**From:** Clerk [REDACTED]  
**Sent:** 09 October 2019 12:28  
**To:** Planning.Responses <Planning.Responses@arun.gov.uk>  
**Subject:** RE: Planning Consultation on: BN/73/19/PL

**APPLICATION NO:** BN/73/19/PL  
**Registered:** 11th September 2019  
**Site Address:** Barnham Court Farm Church Lane Barnham PO22 0BP  
**Grid Reference:** 495619 103473  
**Description of Works:** Change of use of The Little Yard to independent dwelling & the stationing of up to 4 No. Shepherd Huts to be used as tourist accommodation. This application affects a Public Right of Way, may affect the setting of a listed building & affects the character & appearance of the Church Lane, Barnham Conservation Area.

Site 3 Long Wood

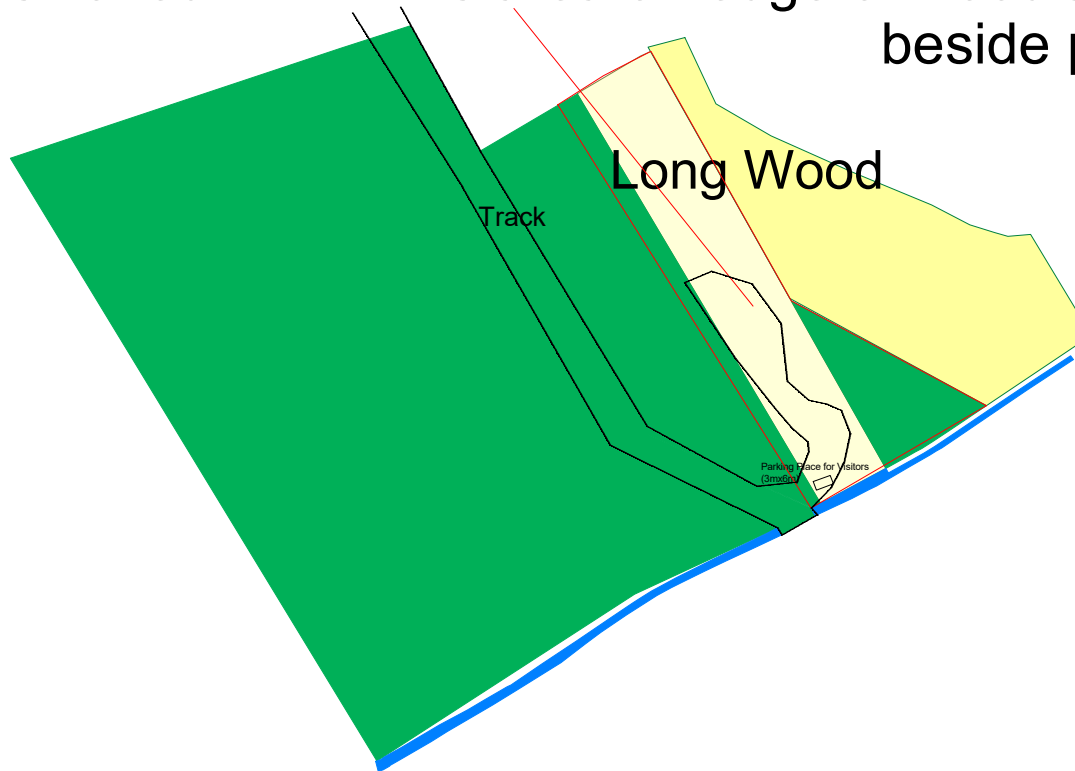
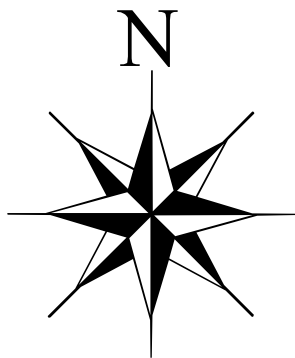
At a meeting of the Planning & Environment Committee of the Barnham and Eastergate Parish Council the Committee resolved to raise no objection to this application provided a condition was imposed that restricted the number of huts placed on Site 3 to 1 hut at any time. Also there should be no outside lighting provided that would impact on the wildlife in the area.
